Application No: M/59/20/HH
Site Address: 56 Southdean Drive Middleton-On-Sea PO22 7TB
Description of works: Extension and remodelling of existing dwelling with a new top storey, front, rear and side extensions. New garden store to rear, new garage to front.

Thank you for your internet representation made on 18th September 2020 which has been recorded as an objection with the comments as follows:

CLIENT **Mark & Mellissa Muscat**
PROJECT **56 Southdean Drive**
DRAWING TITLE **Proposed Second Floor**

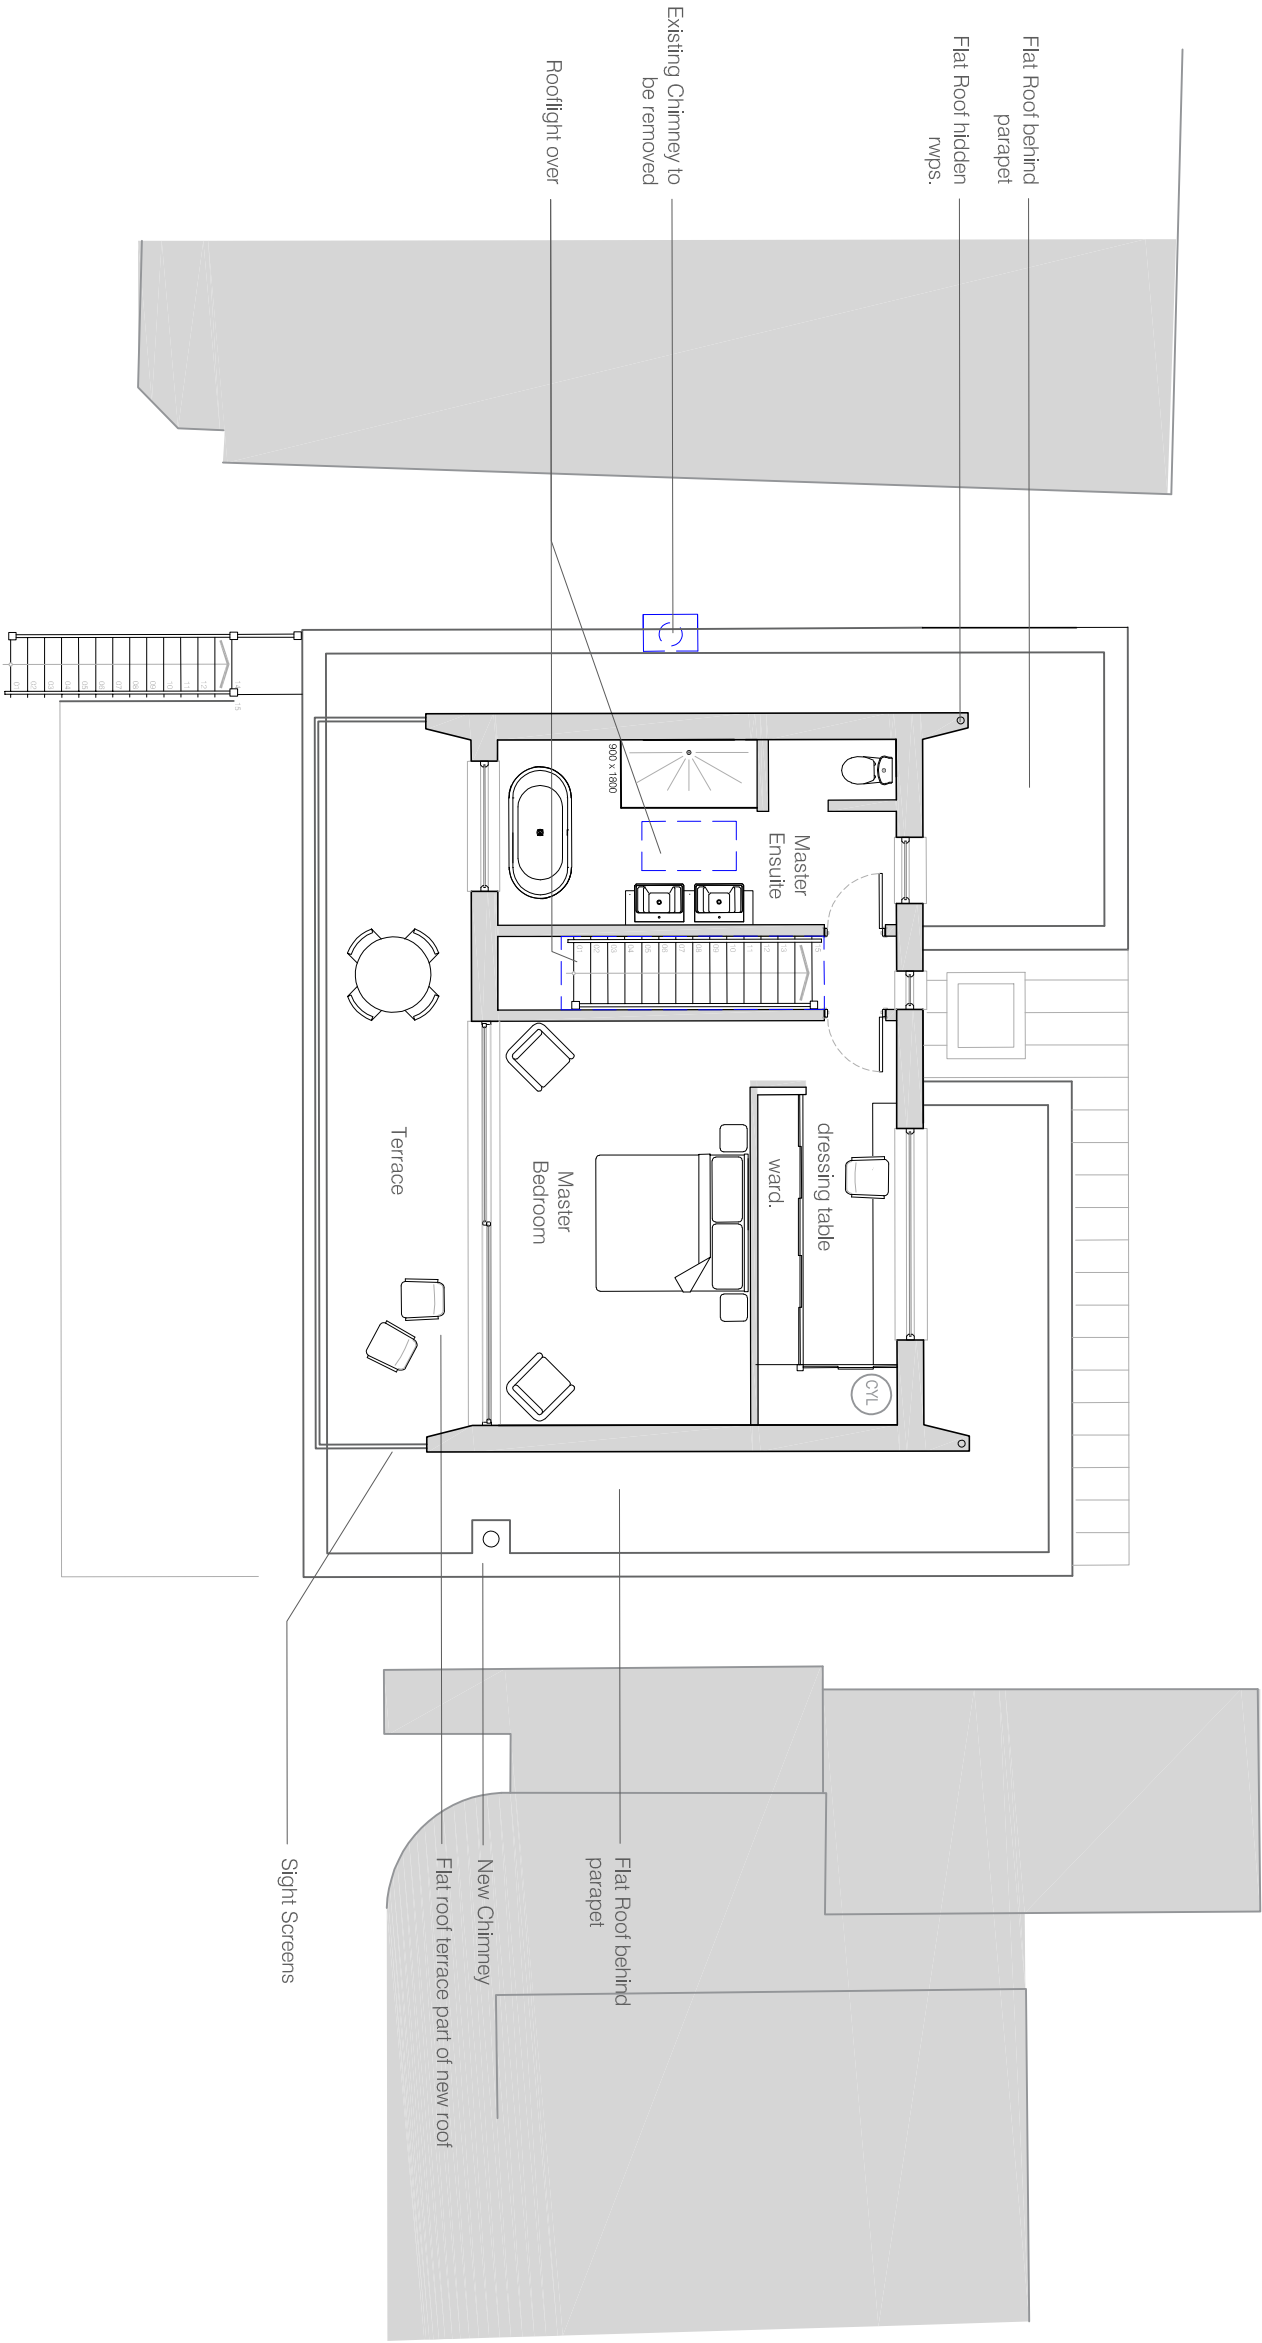
2. The proposed second floor balcony and open staircase at the rear will impede the view of the beach from my property. Furthermore, the exposed staircase whenever it is used will, by virtue of it not being enclosed, inevitably create unacceptable levels of noise given the proximity to my property and my sleeping accommodation. Obviously once constructed it is available to be used for 24 hours - day and night.

7. The gates blocking access to the second floor flat roof should be fixed (but removable for access). Any hinged access will likely attract use of this area for activities other than necessary maintenance.

8. The second floor terrace will overlook our property and severely compromise our privacy. Any activity in

CLIENT **Mark & Melissa Muscat**
PROJECT **56 Southdean Drive**
DRAWING TITLE **Section + Outbuilding Elevations**

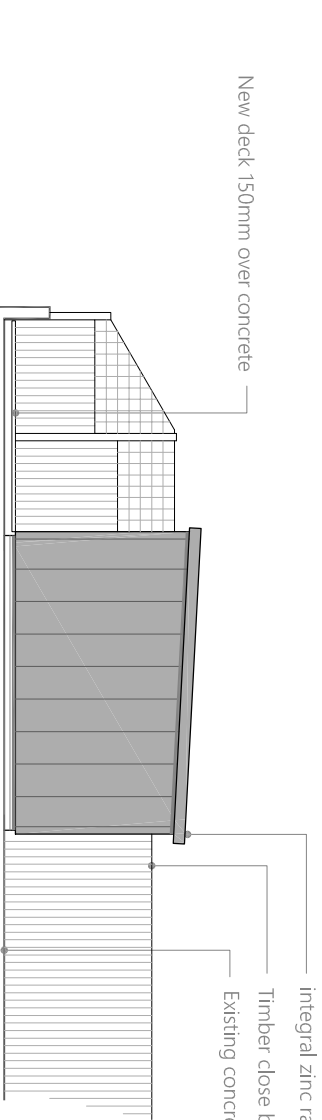
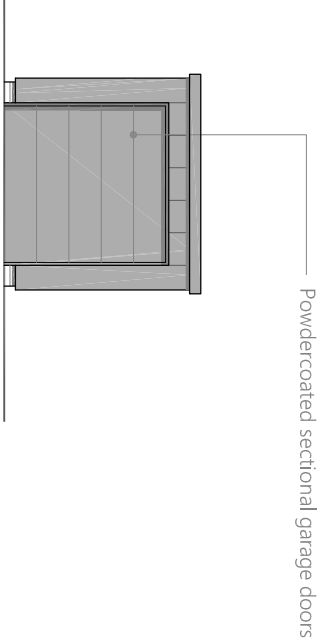
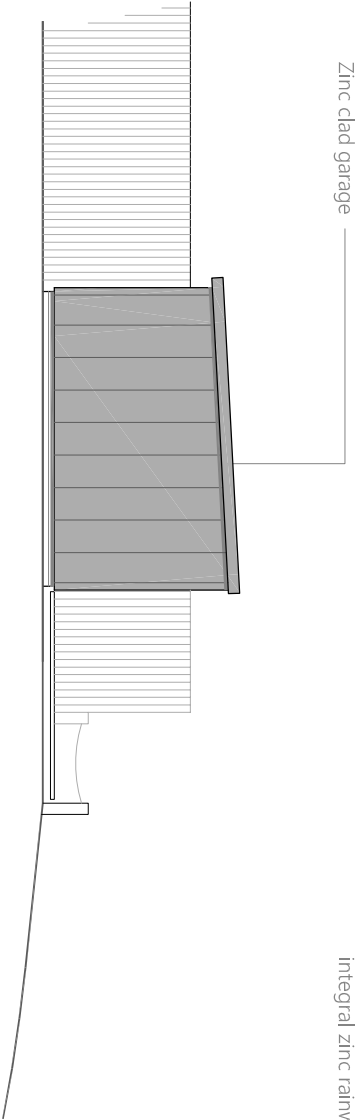
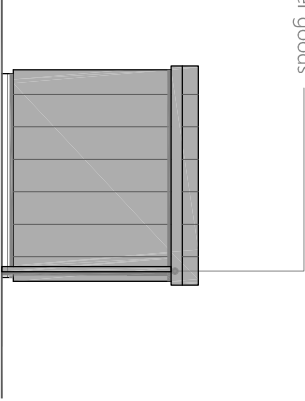
3. The size of the external storage in the rear garden will be very visible from the beach and does not appear to be in keeping with the other surrounding seafront properties. It is substantially larger than the existing wooden storage area and is likely to restrict the view from my property to the beach.

Front Garden Store North Elevation

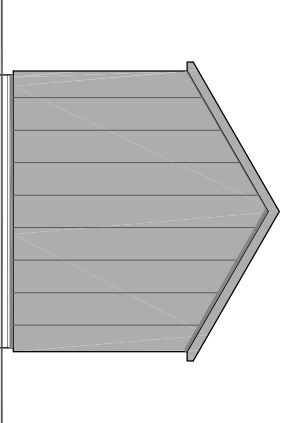
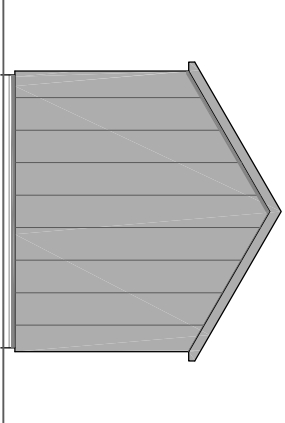
4. The size, and positioning of the front garden storage (garage) is not in keeping with the other buildings in the road.

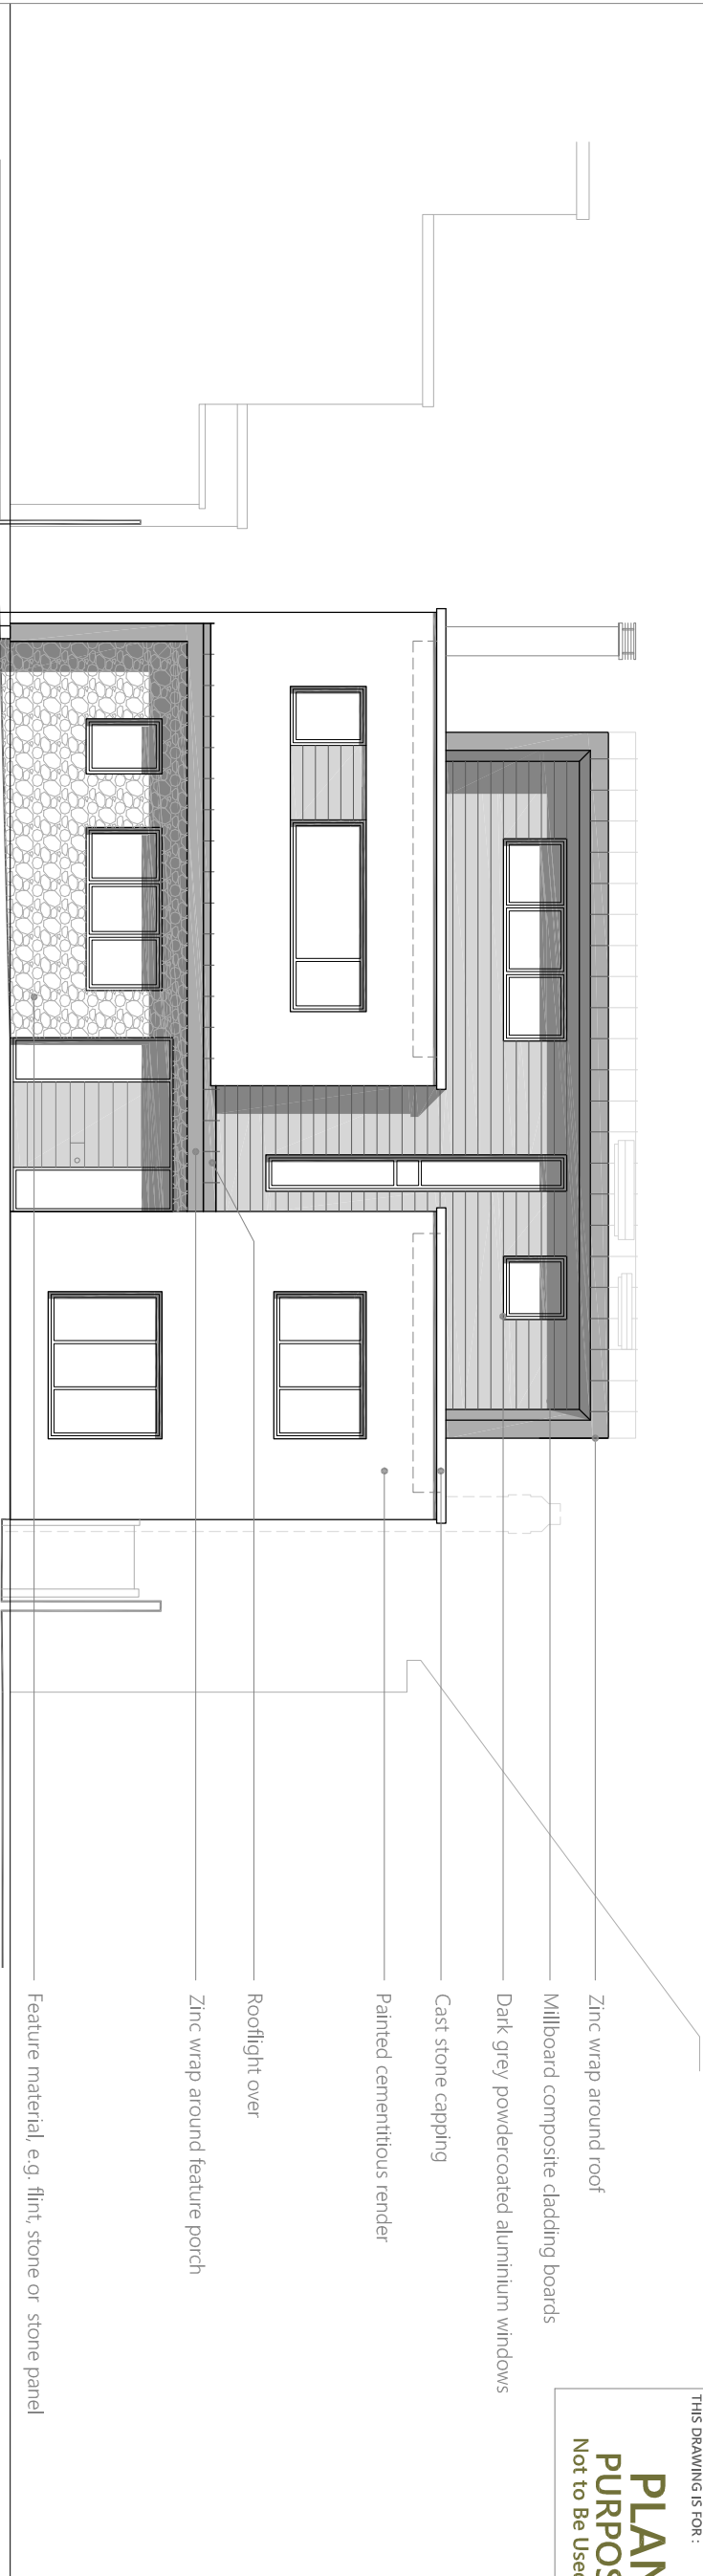
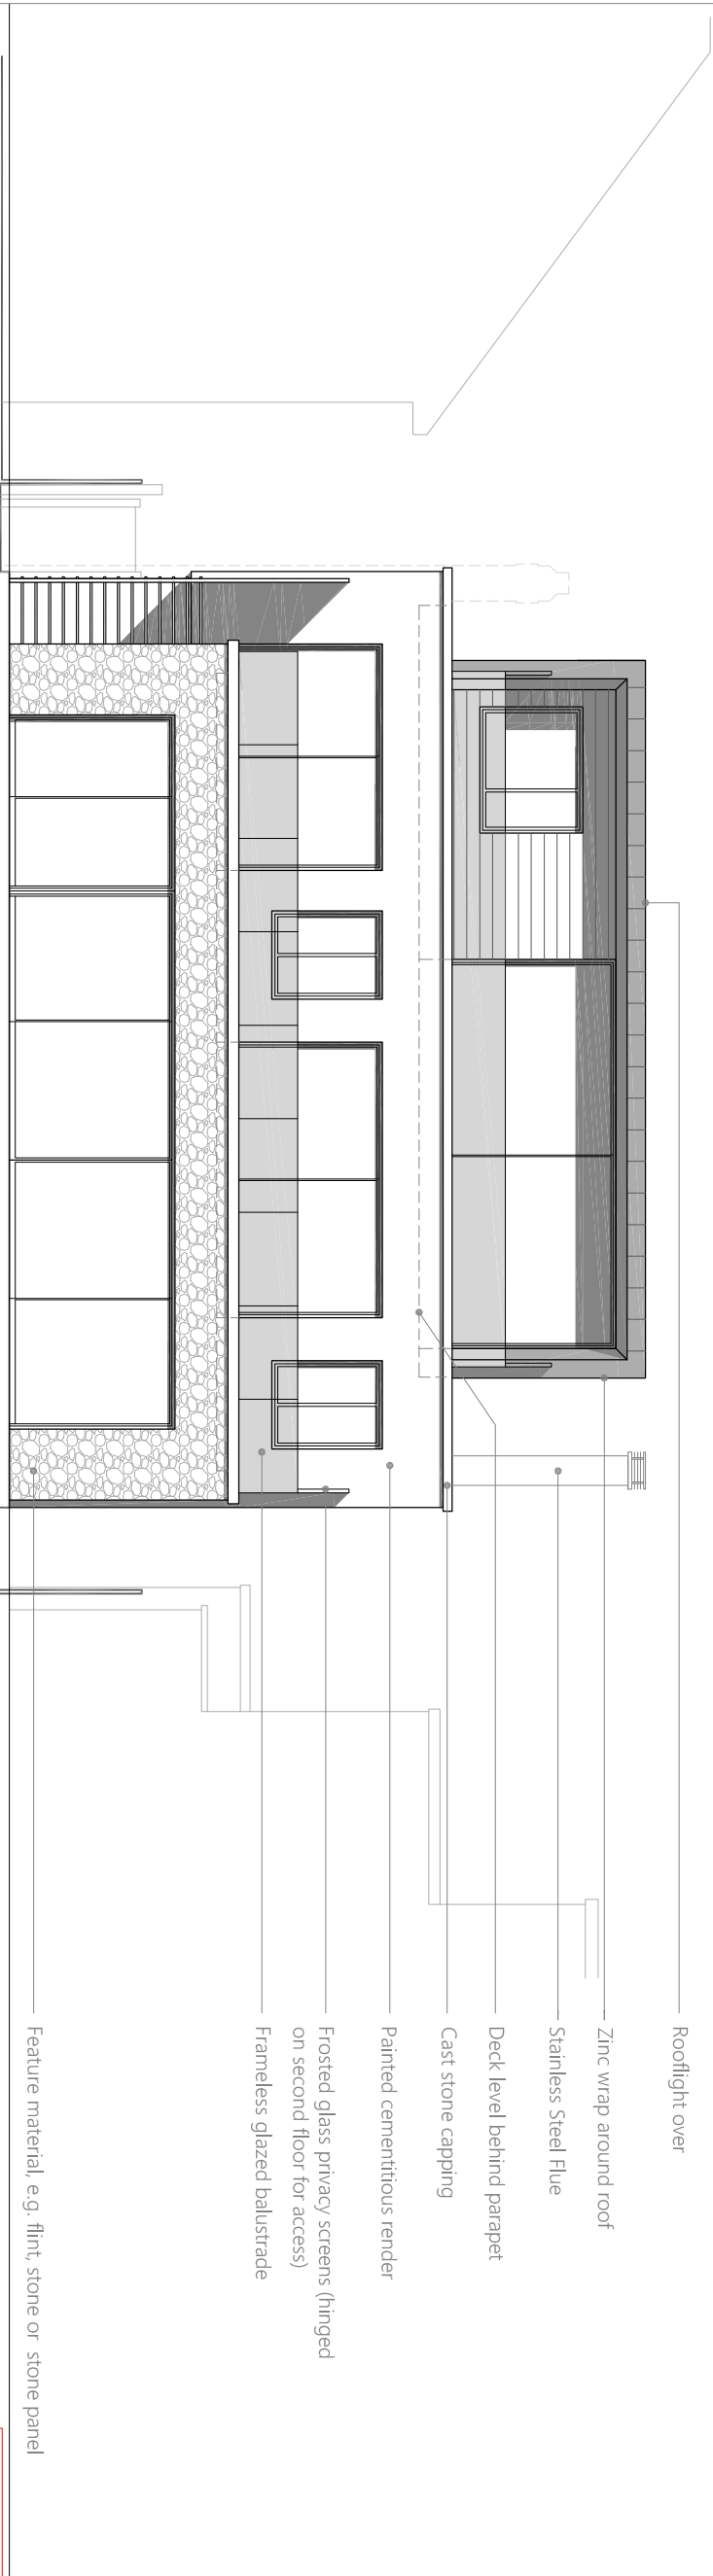
1. The overall increase in the volume of space will create a building totally different to the existing property. It is not in keeping with the majority of properties in the road and will be extremely prominent for anyone using the beach. To add a third storey with a total height above that of the existing eaves roof will material change the outlook from the beach. The nature of the plans in terms of both size and design make it look like a new development not a straight forward extension to an existing property.
